December 13, 2021
GPD PN: 2020379.01

**REVISIONS TO
APPROVED DOCUMENTS
for
2778 NC-24
Cameron, NC 26236**

Revision 1 – Tenant Coordination

1 FOUNDATION PLAN
Scale: 1/4" = 1'-0"

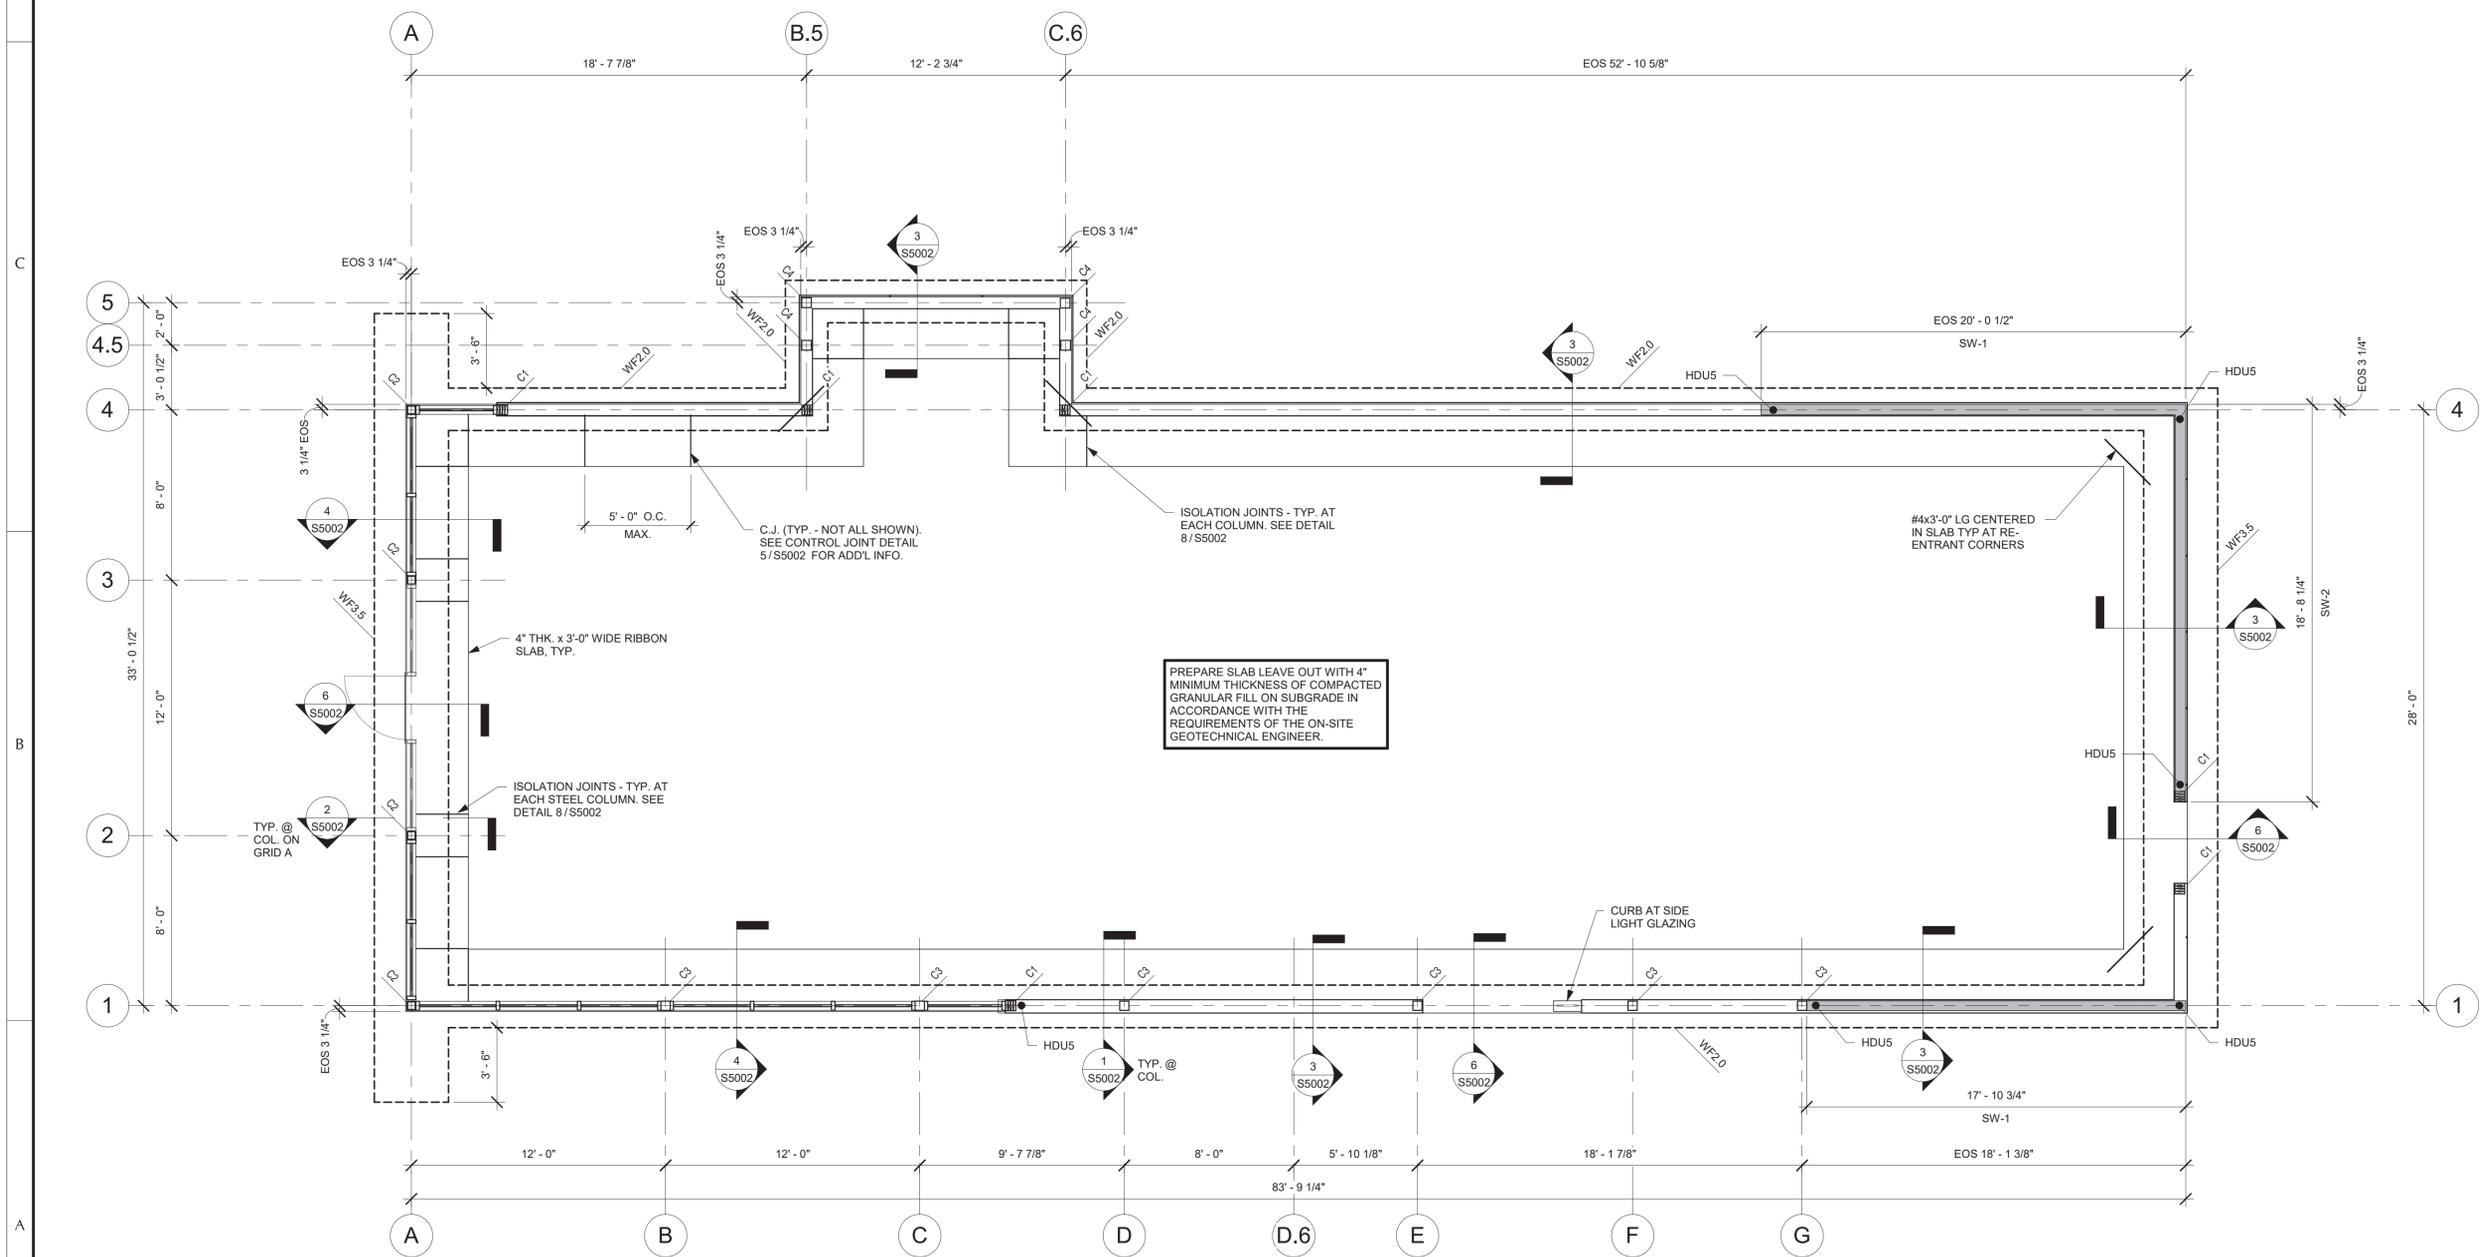
- 1. **Sheet S1001:**
 - a. Ribbon slab revised to thinner slab haunch. Note revised.
- 2. **Sheet S5002**
 - a. Details revised to reflect slab haunch.
- 3. **Sheet A1101**
 - a. Ribbon slab revise to thinner slab haunch. Note revised.
- 4. **Sheet 1501**
 - a. Keyed Note 8 revised to clarify fixture position in new finish.
- 5. **Sheets A2001 & A2002**
 - a. New finish added to underside of canopy. Exterior finish schedule and Keyed Note 7 revised.
- 6. **Sheets A3001, A3002, A3003, A5001**
 - a. Sections and details revised to reflect thinner slab haunch.
- 7. **E1002**
 - a. Additional lighting added to canopy at main entry.

S1001

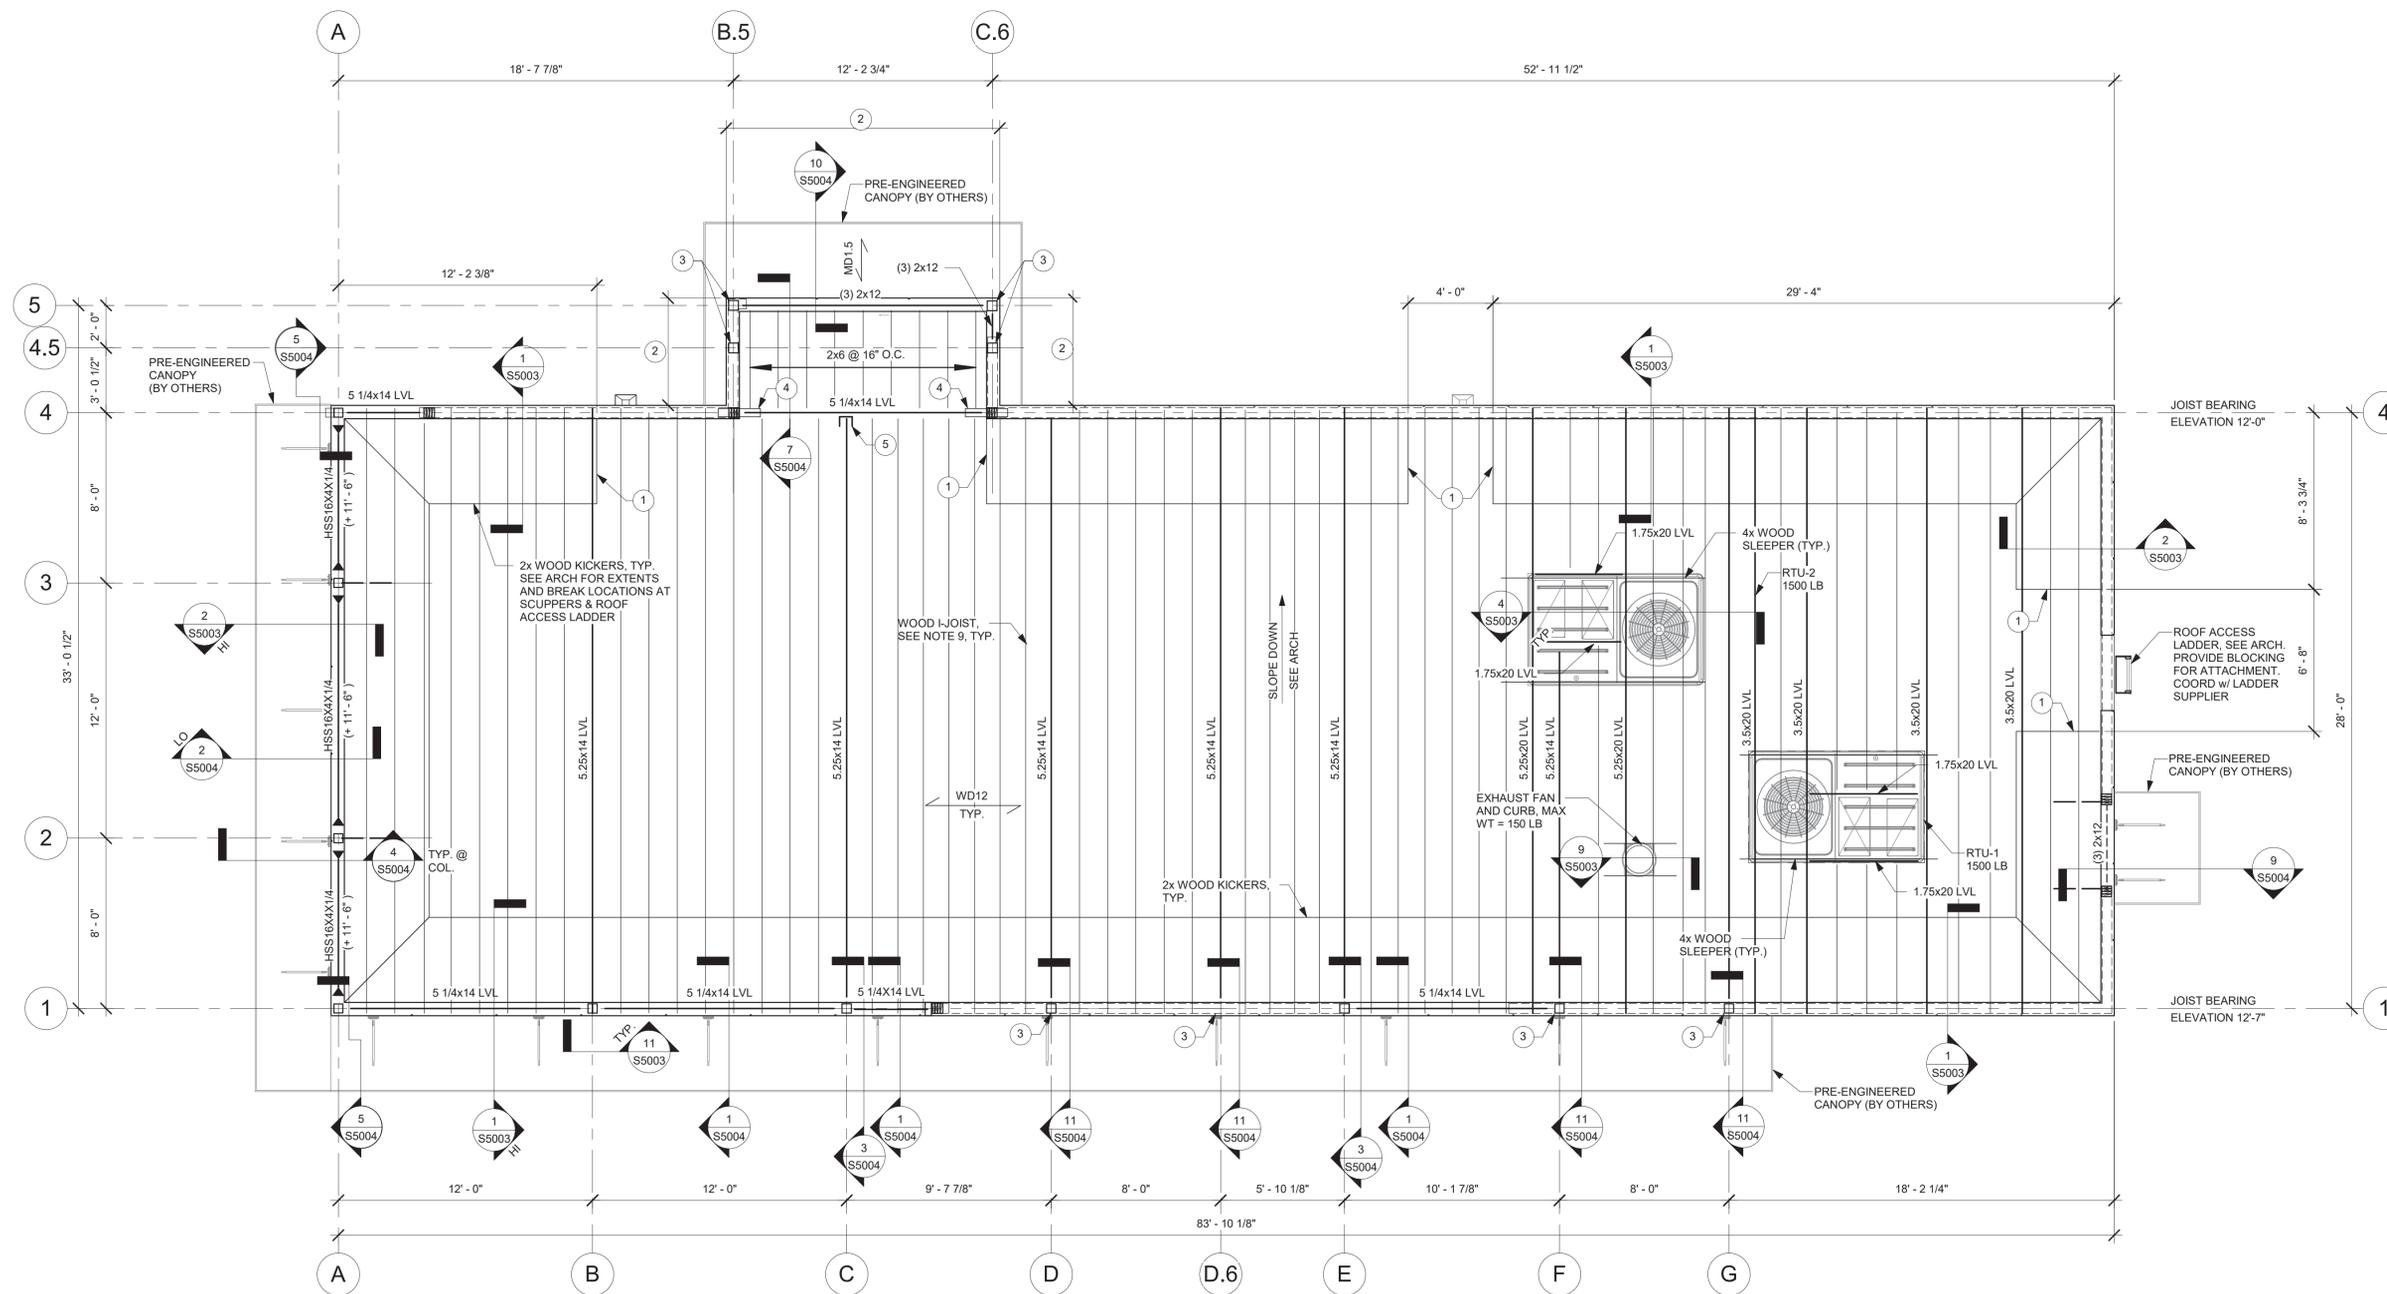
- a. Joist and LVL depths revised. Joist bearing elevations revised accordingly.
- b. Canopy note revised for clarity.

- a. RTU make & model revised. Framing below RTU's revised accordingly.
